October 27, 2017

**RE: ADU14-003, CAO17-005, SHL17-007-004, Second Review Letter  
Land Use Applications for proposed home, ADU driveway and retaining wall  
construction within a steep slope along the shoreline for the Lady Bug Trust.  
DEV17-009 Impervious Surface Deviation Application has been withdrawn.**

RE: ADU17-003, CAO17-005, SHL17-007, SUB17-004 Second Review Letter  
Land Use Applications for proposed home, ADU, driveway and retaining wall construction within  
a steep slope along the shoreline for the Lady Bug Trust

- ADU shall be consistent with the roof pitch, siding, and windows of the proposed main house.

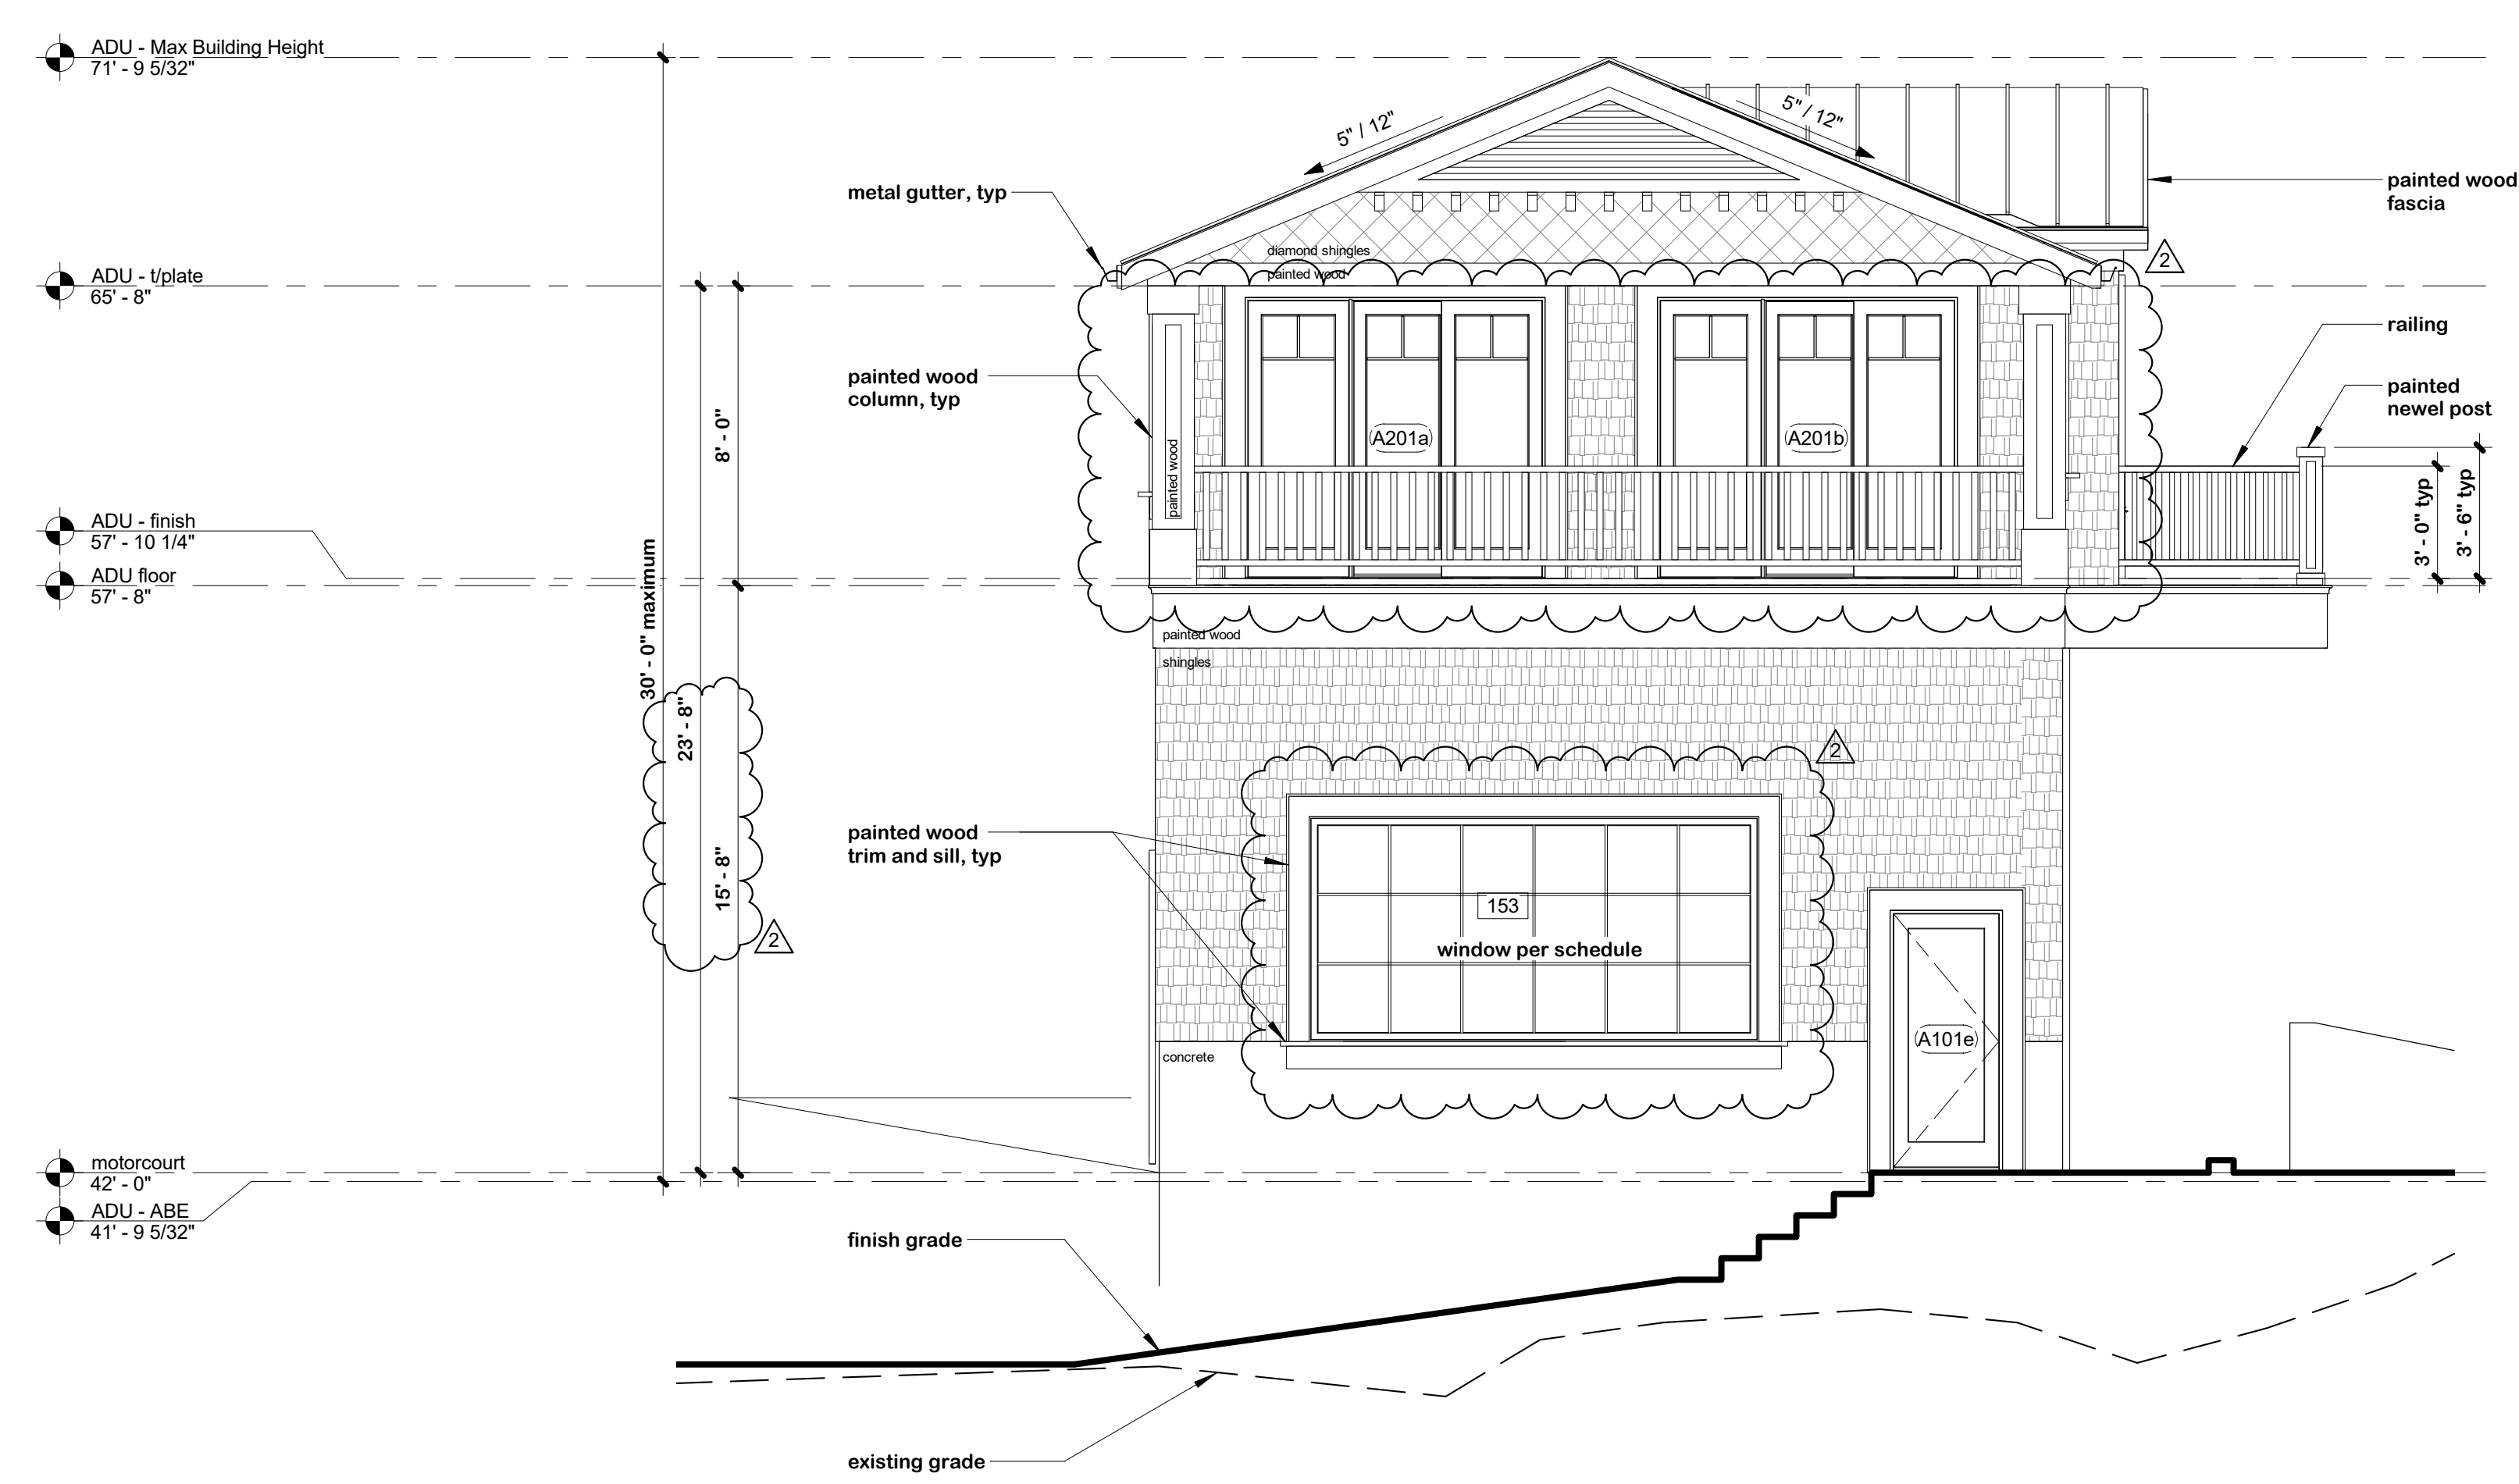
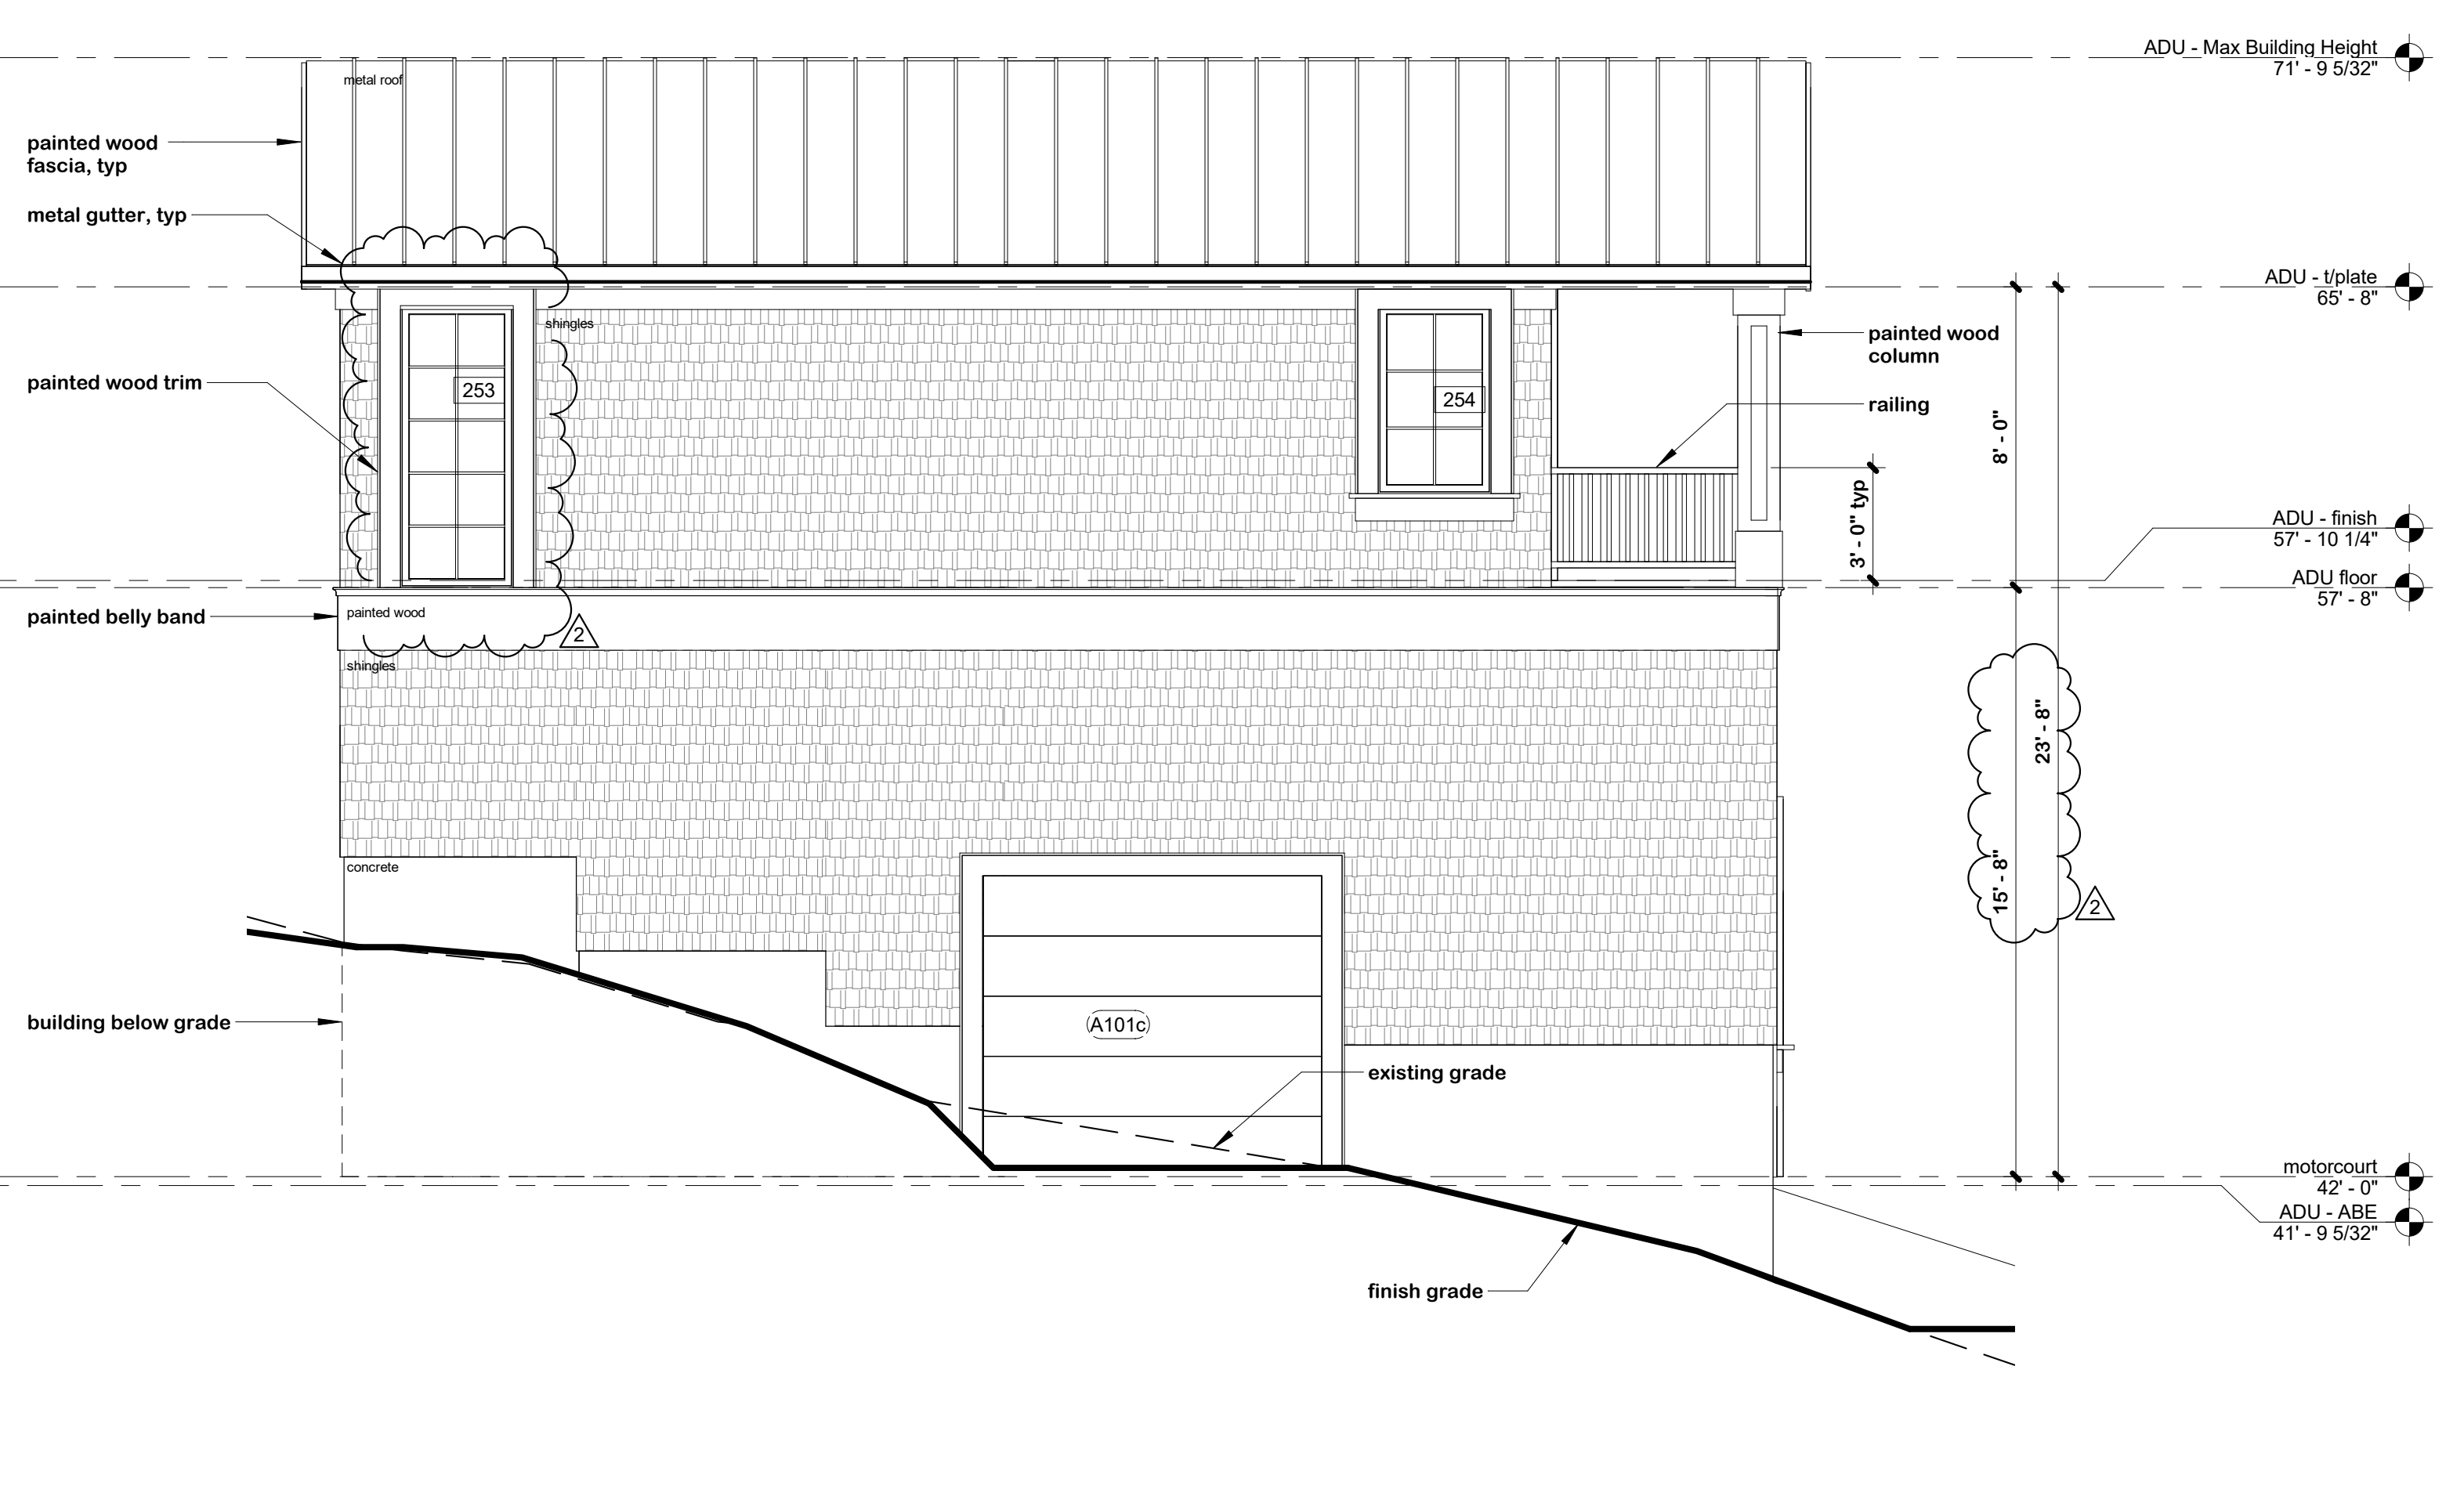
8. *Please provide building elevations drawings that the ADU shall be designed consistent with the existing roof pitch, siding, and windows of the principal dwelling unit.*

**Please see note 1 on sheet A2 of the ADU elevations. The ADU is designed consistent with the main house.**
